Colorado Springs, CO

Final Report - Corrections Required **Application No. ANEX-24-0005**

Description : Matrix Design Group on behalf of Colorado Springs Equities LLC is submitting a serial annexation petition for seven parcels and Land Use Plan/Rezoning exhibit for a portion of the subdivision known as Rock Creek Mesa.

Document Filename : 224.023-LEGAL-RCM ANNEX 5.pdf

ROCK CREEK MESA ADDITION NO. 5

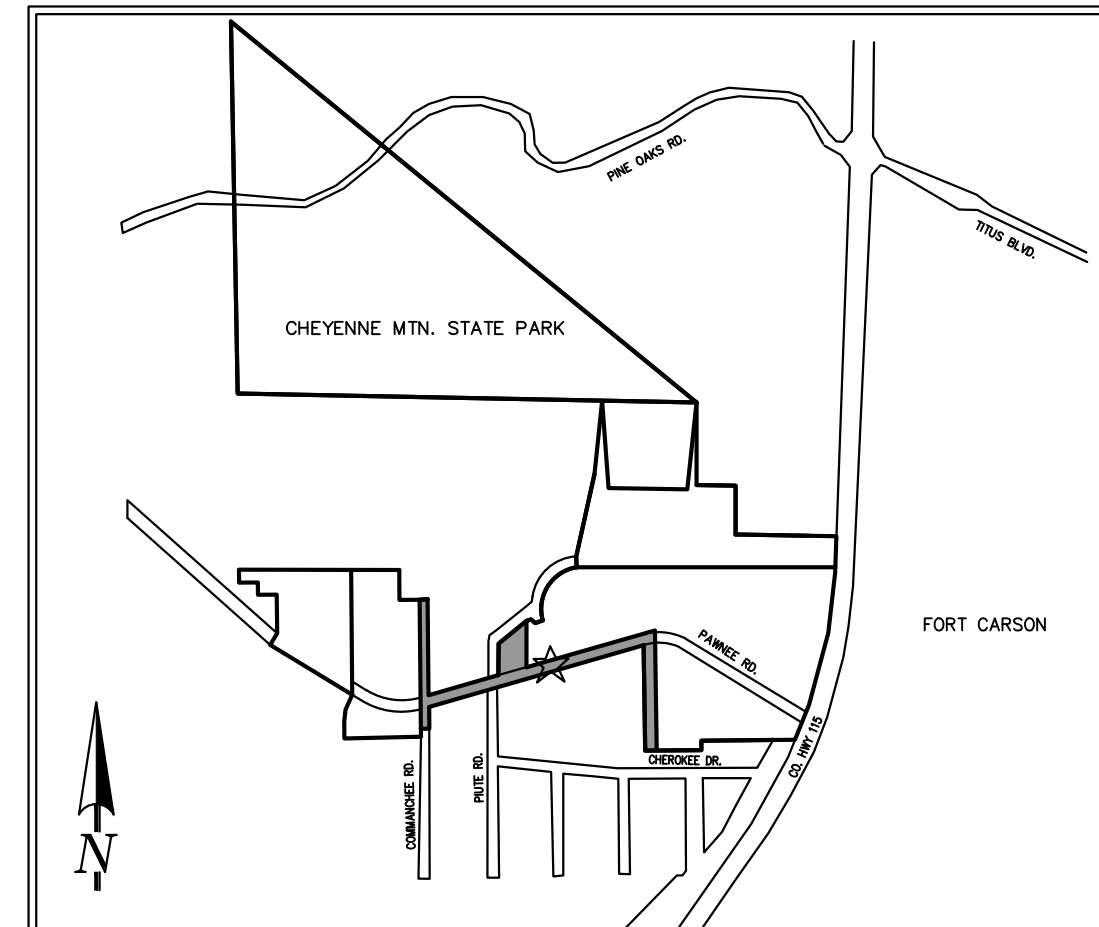
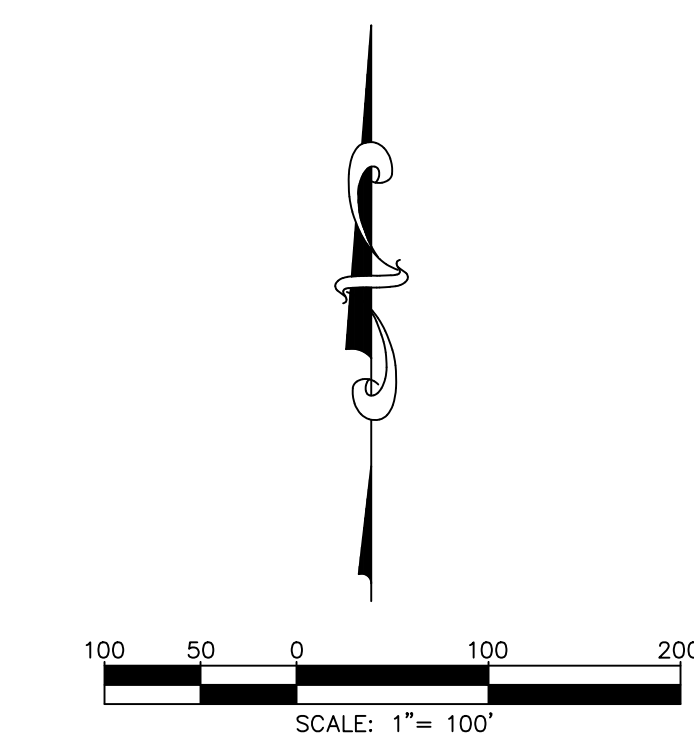
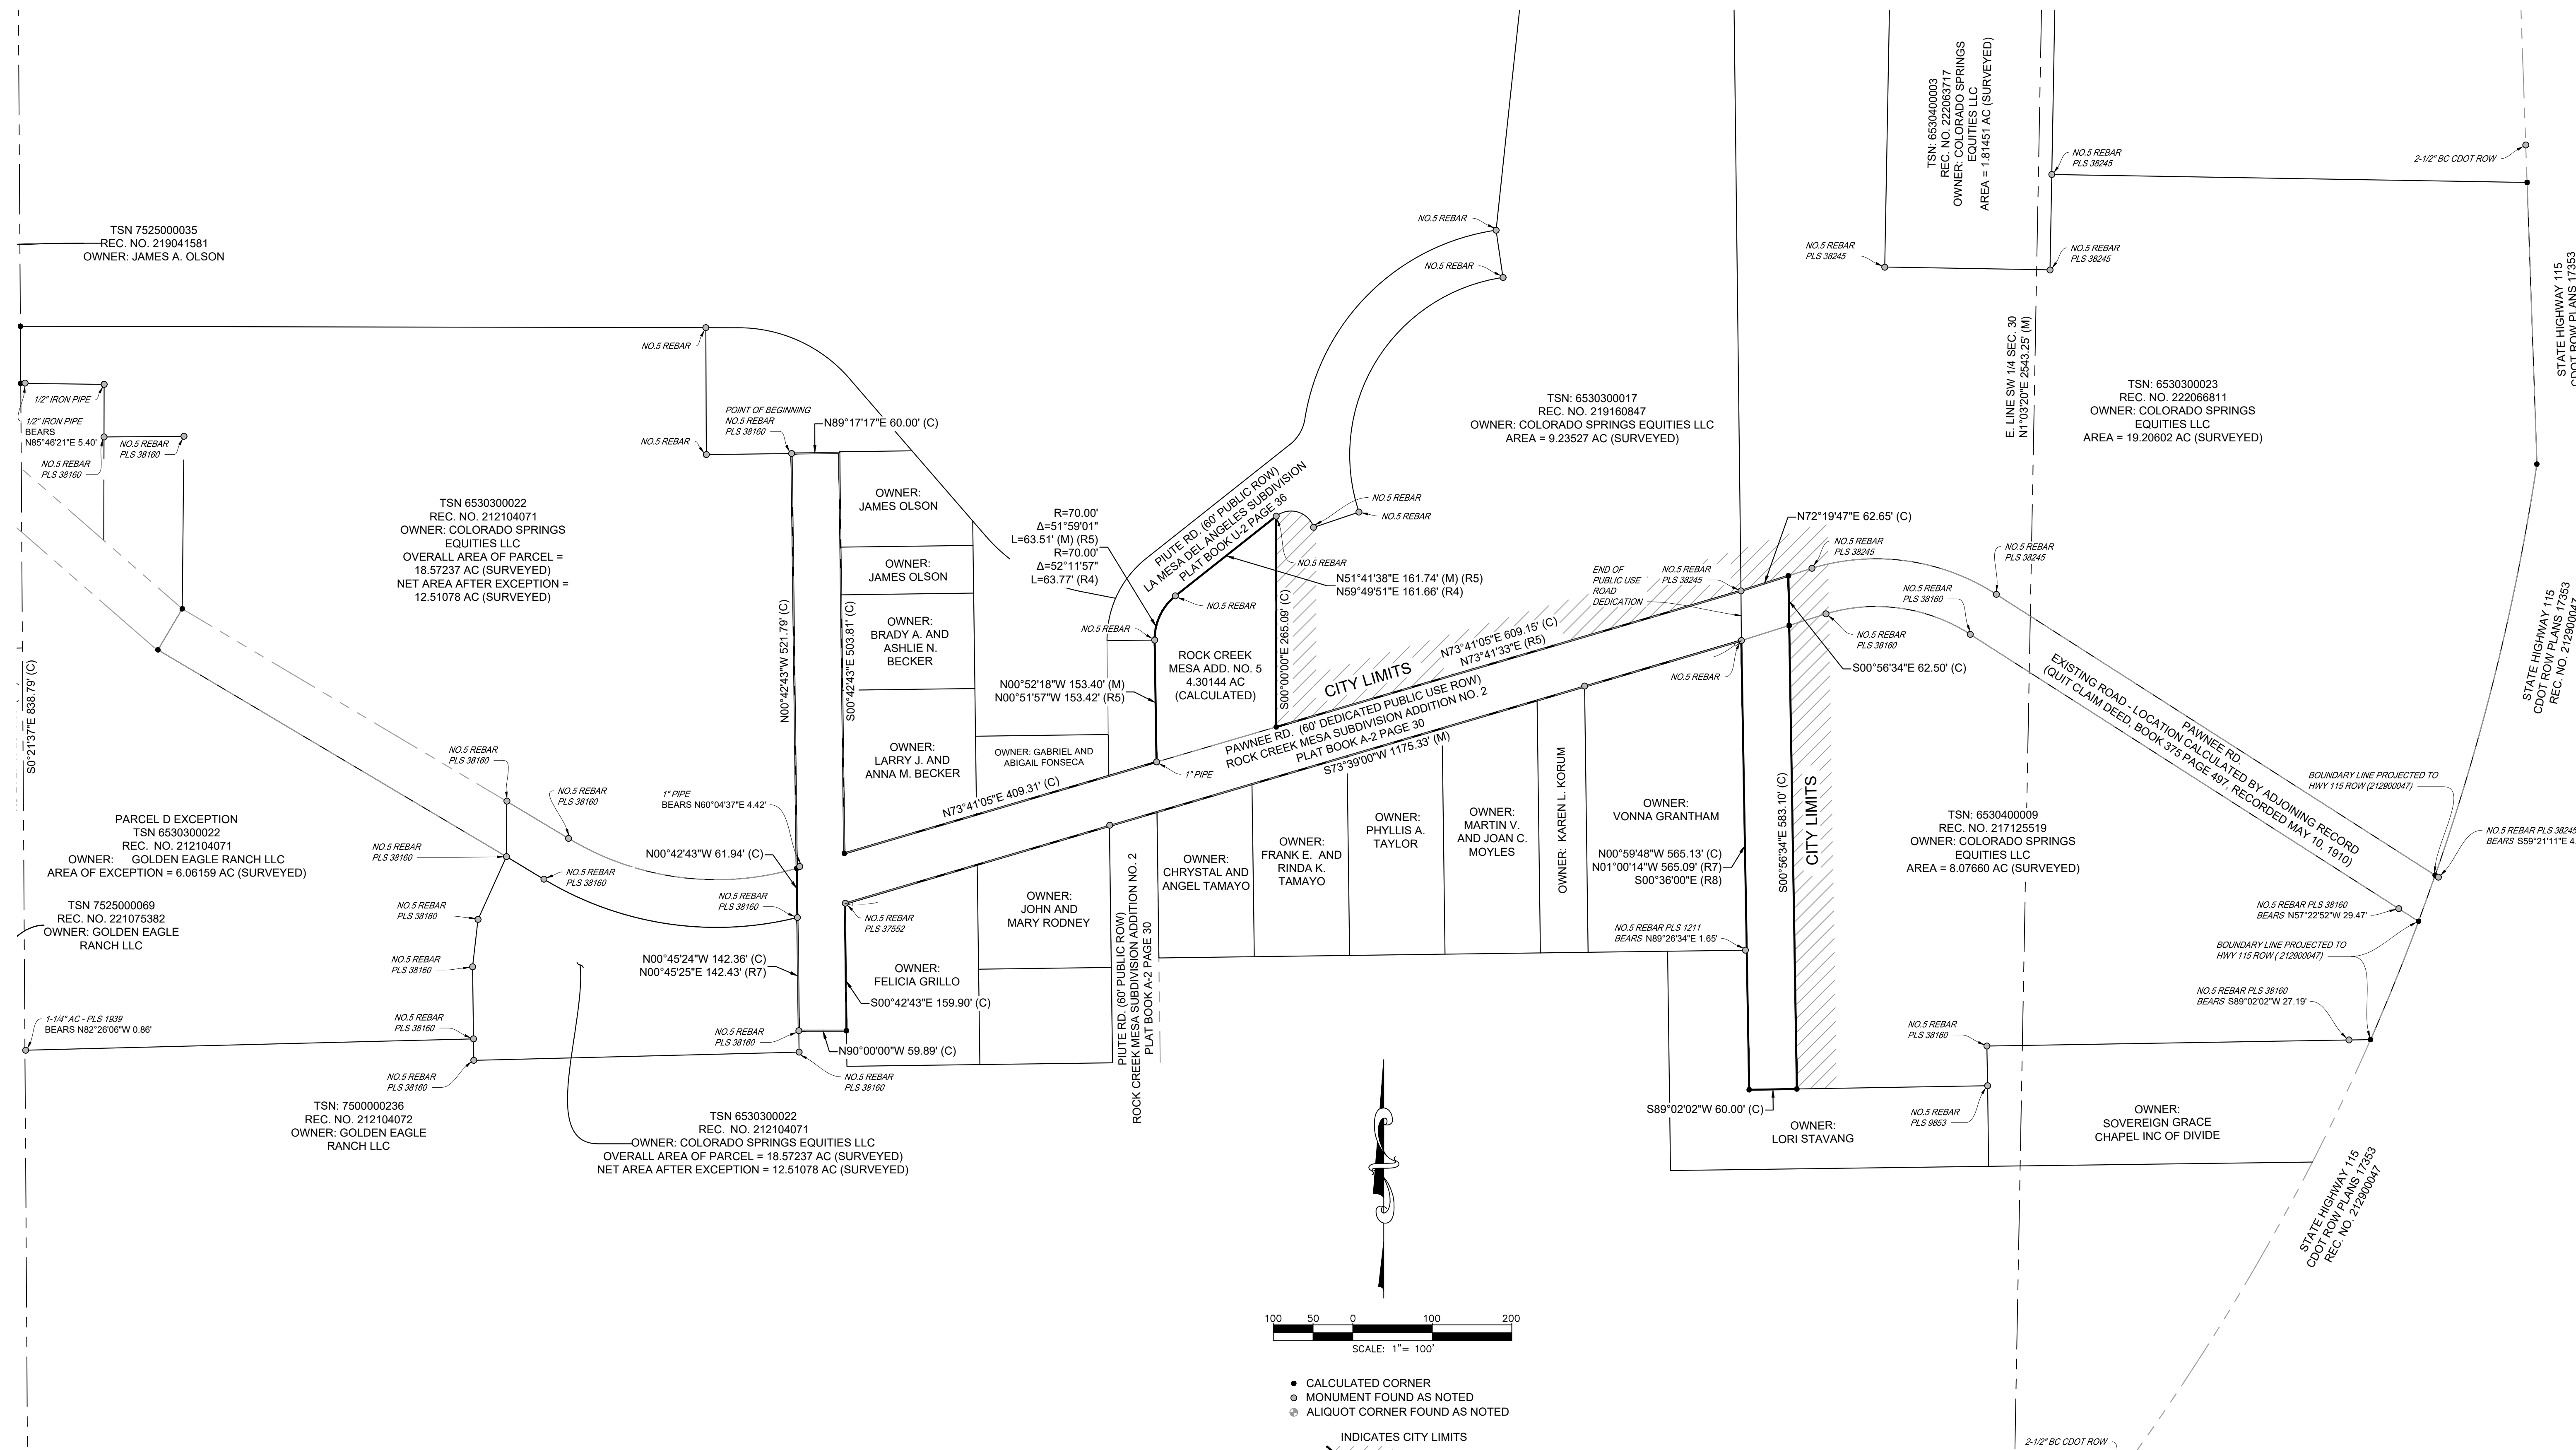
Comment ID	Page Reference	Reviewer : Department	Review Comments
16	1	Gabe Sevigny : Planning	Please be sure that any additional comments on the Annexation Plat are also reflected here and vice versa
17	1	Gabe Sevigny : Planning	Add ANEX-24-0005 to each sheet
36	1	Cory Sharp : Planning	Please revise exhibit A to: Rock Creek Mesa Addition No. 5
37	1	Cory Sharp : Planning	N73-41-05E closure
38	1	Cory Sharp : Planning	N90-00-00W closure
39	2	Cory Sharp : Planning	Please add the area at the end of the legal description

Please revise exhibit A to:
Rock Creek Mesa Addition No. 5

N73-41-05E closure

N90-00-00W closure

Add ANEX-24-0005 to each sheet

Please add the area at the end of the legal description
